Consultation Response from: KC Environmental Health (Pollution & Noise Control)
2024/92105 - Wesley House, Huddersfield Road, Birstall, Batley, WF17 9AZ
Alterations to convert former offices to 21 apartments (Listed Building within a Conservation Area)
Responding Date:
19 September 2024

Responding Officer:
Mohammed Nasim

Responding Ref:
WK202425967

Plan: **Proposed Site Layout and Location Plan**

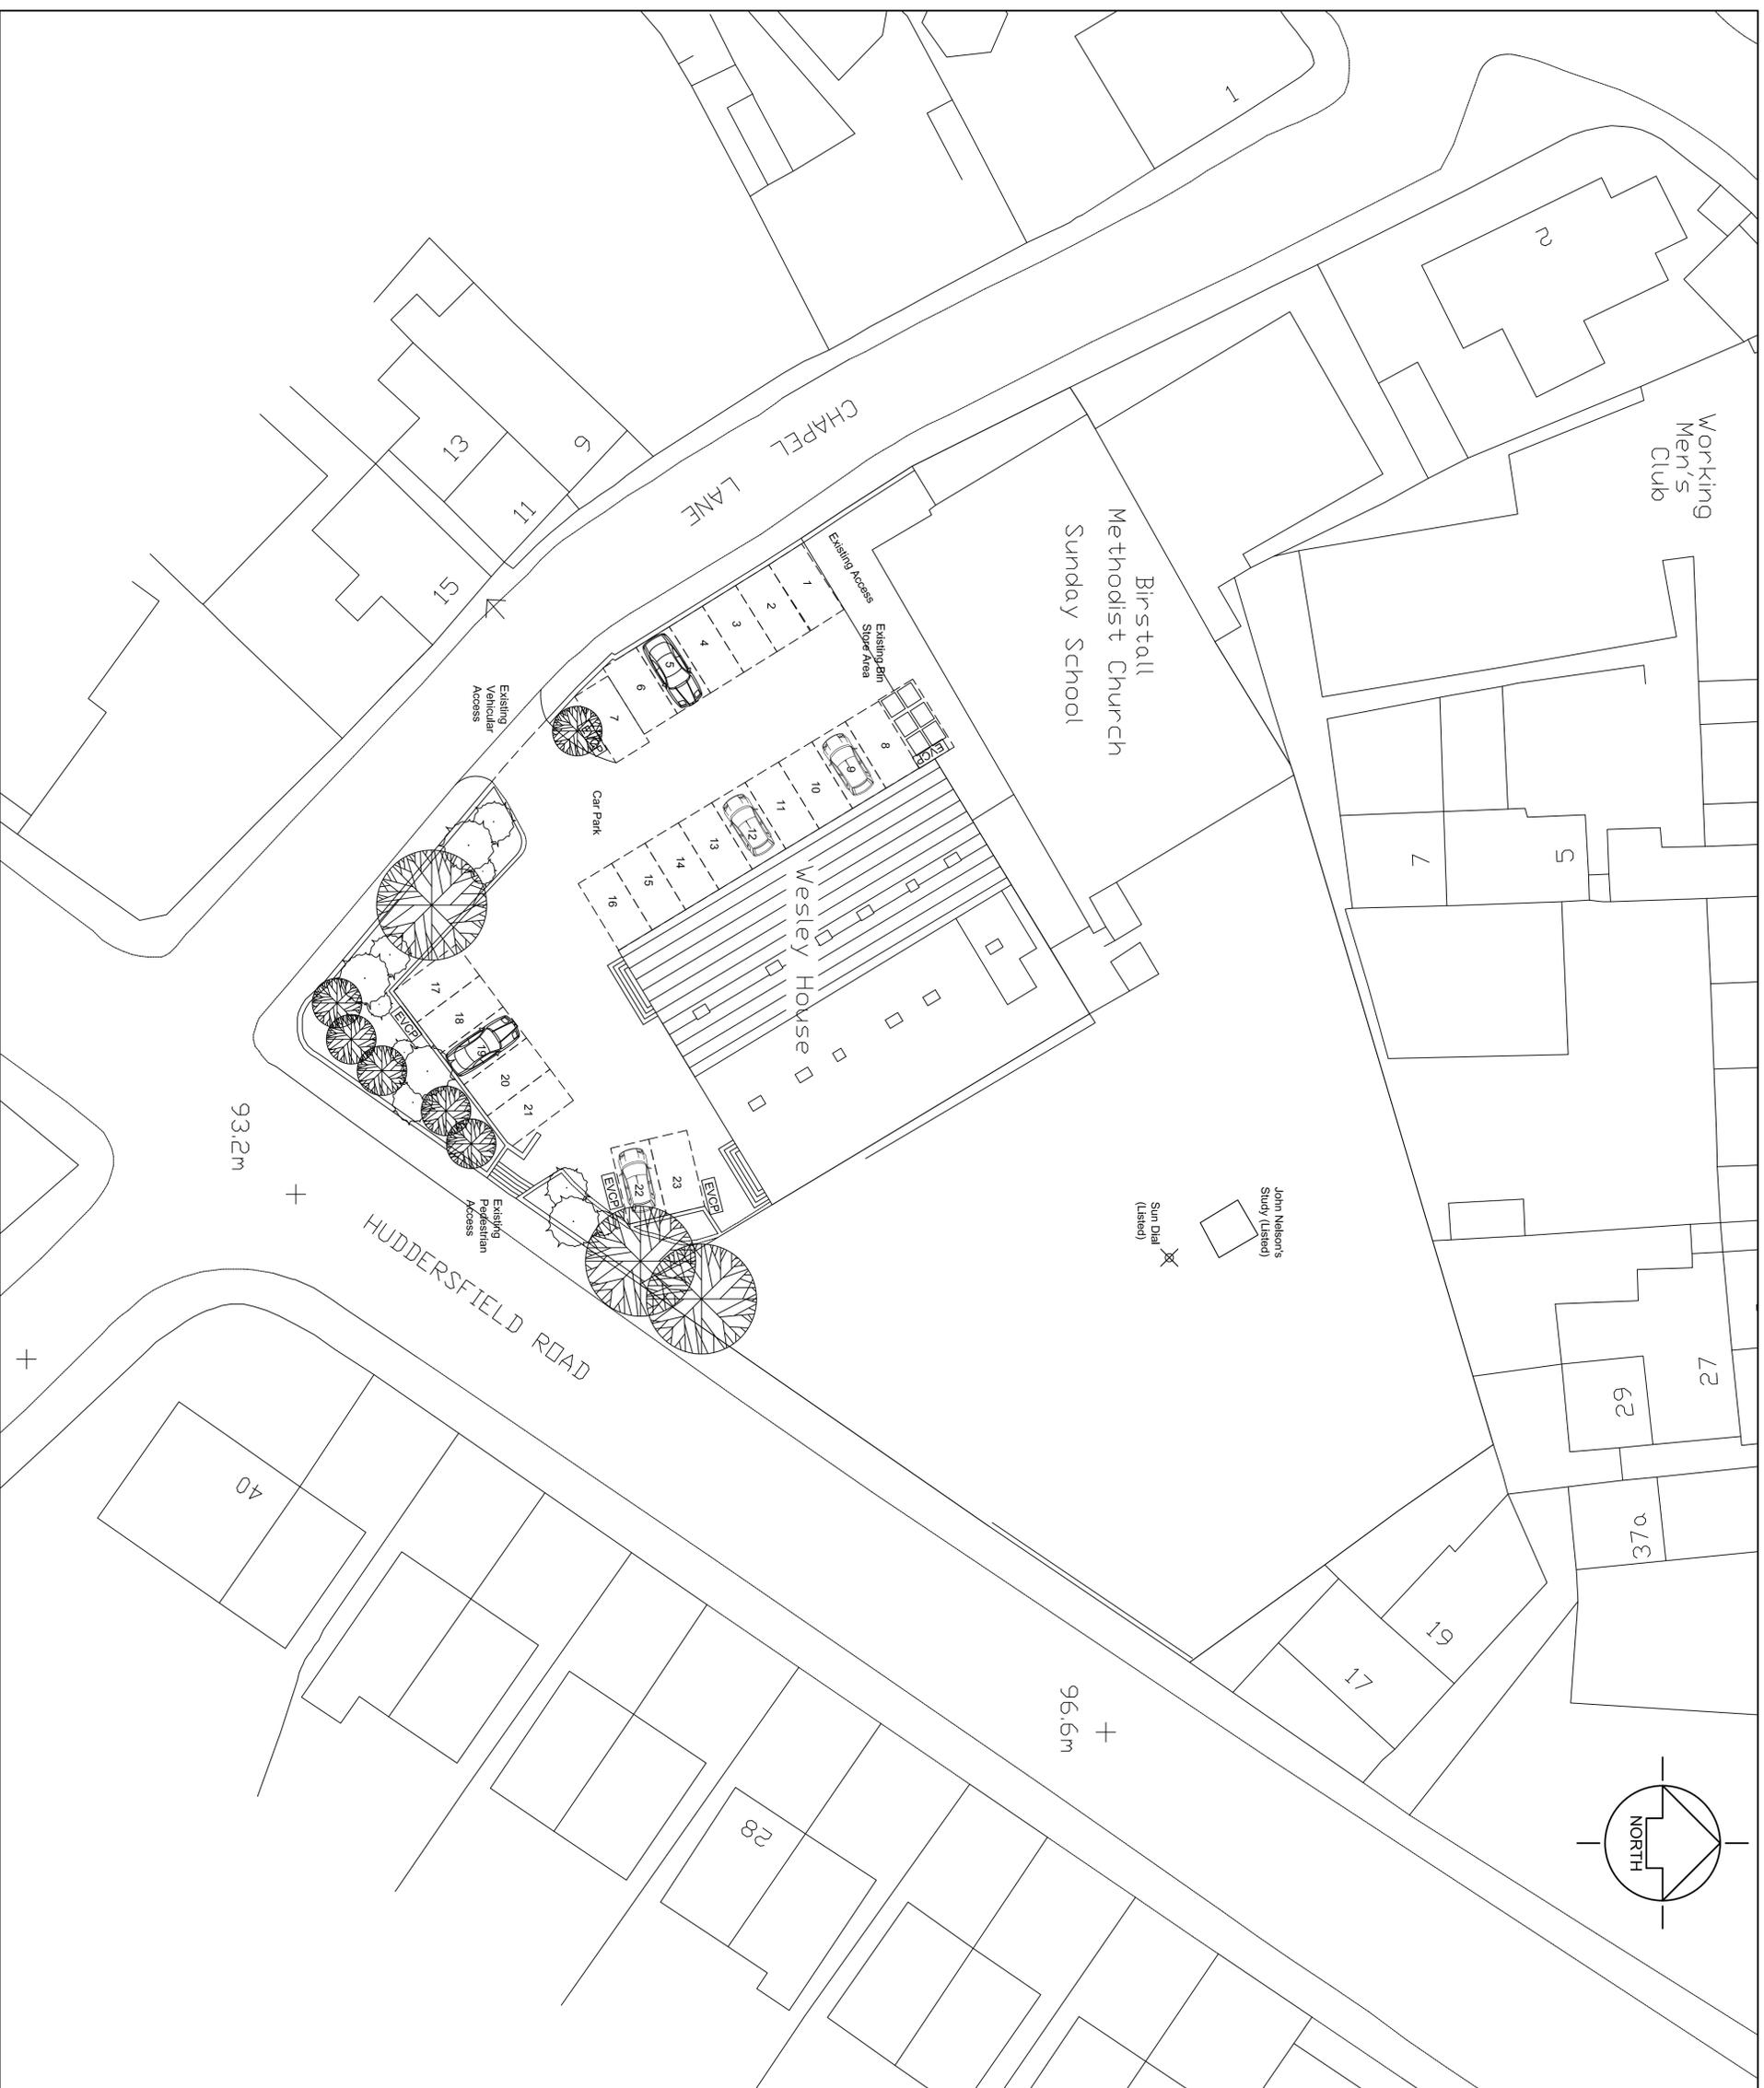
Drawing no. KL/24/1709/01 from PN Bakes dated July 2024 shows 4no. EVCPs. In an application of this nature, it is expected that facilities for charging electric vehicles and other ultra-low emission vehicles are provided in accordance with the National Planning Policy Framework and *Air Quality & Emissions Technical Planning Guidance* from the West Yorkshire Low Emissions Strategy Group. An advisory relating to charging points is therefore necessary.

- Approval under the Building Regulations may also be required, and the applicant should contact their Building Control Provider for further information in relation to Approved Document S.
- The electrical supply of the final installation should allow the charging equipment to operate at full rated capacity and the installation must comply with all applicable electrical requirements in force at the time of installation.
- To futureproof the development, we would encourage the applicant to provide these in accordance with the current *Air Quality & Emissions Technical Planning Guidance* from the West Yorkshire Low Emissions Strategy (WYLES) Group
